Subject: RE: AW/123/11/T and AW/124/11/TC - 34 The Drive, Aldwick

Location Plan

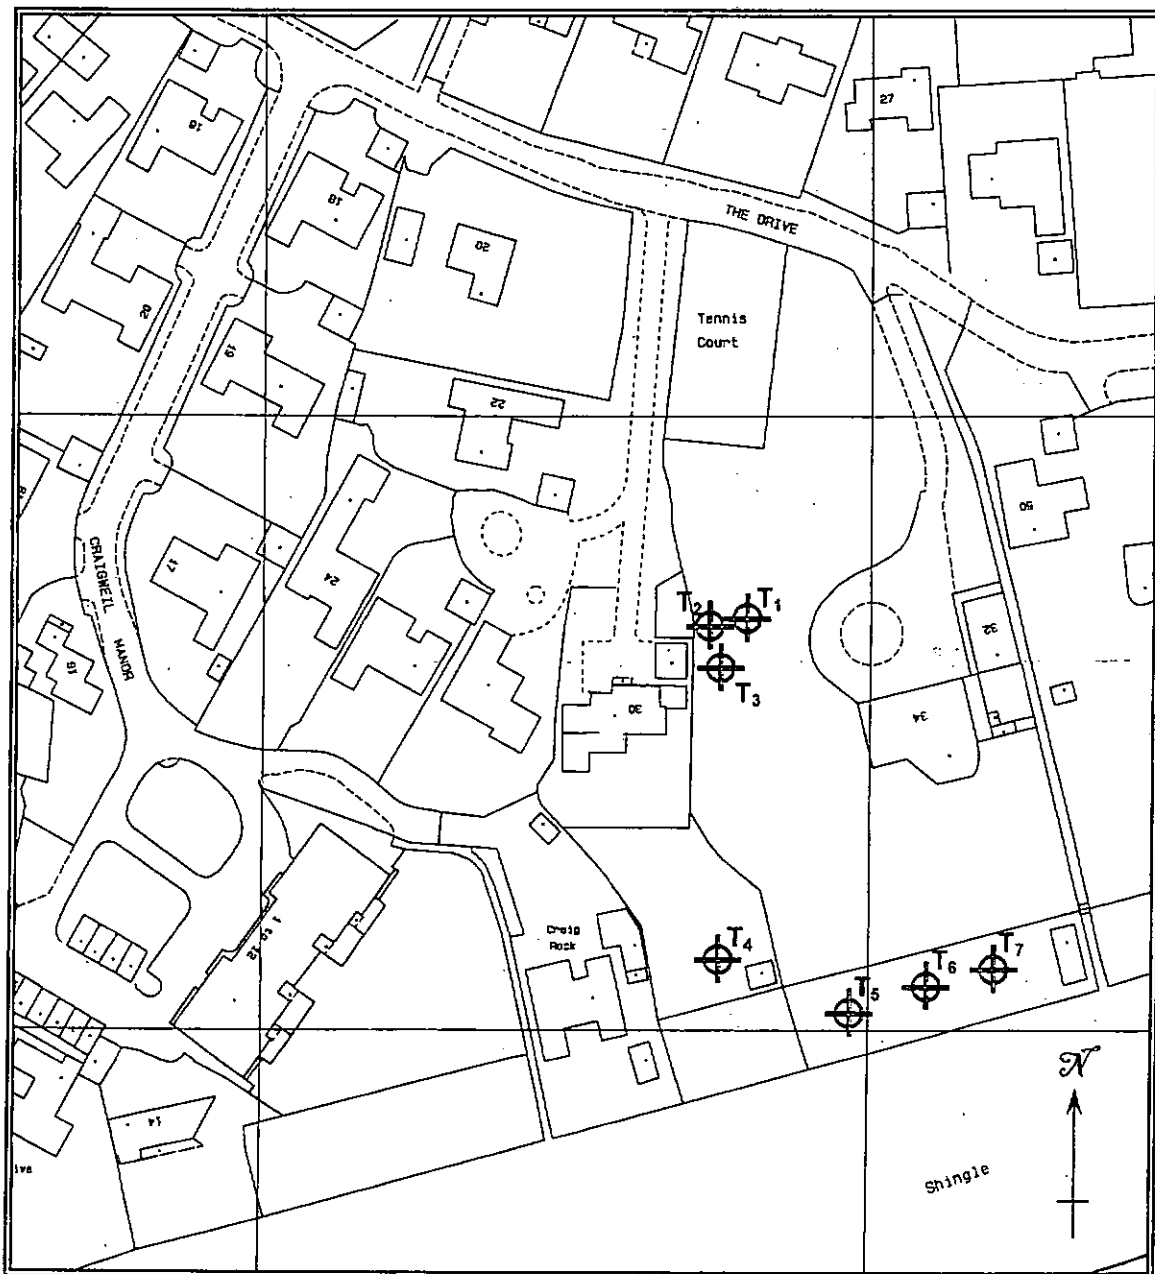
I have surveyed the trees and have no objection to the pruning of T1,2 and 3 as they are difficult to see from a public place and where the Bay trees would be younger than the 1958 Area TPO.

The two Golden Macrocarpa and three evergreen Oaks can be seen from the shore and provide good amenity. The application refers to the felling of one Macrocarpa (T4) to encourage the better growth of the other. However they both provide good amenity and I would recommend that its removal be refused. The three Evergreen Oaks (T5-7) have been shaped over the years by the prevailing salt laden south-westerly winds to create a windswept and asymmetric tree line. Addressing this natural crown imbalance by pruning them hard from the north east to form individual trees would look odd and out of character and is not a good reason to allow the work, and therefore should not be recommended. The TPO review of the trees has highlighted T4,5,6 and 7, as worthy of protection and their importance as good landscape features.
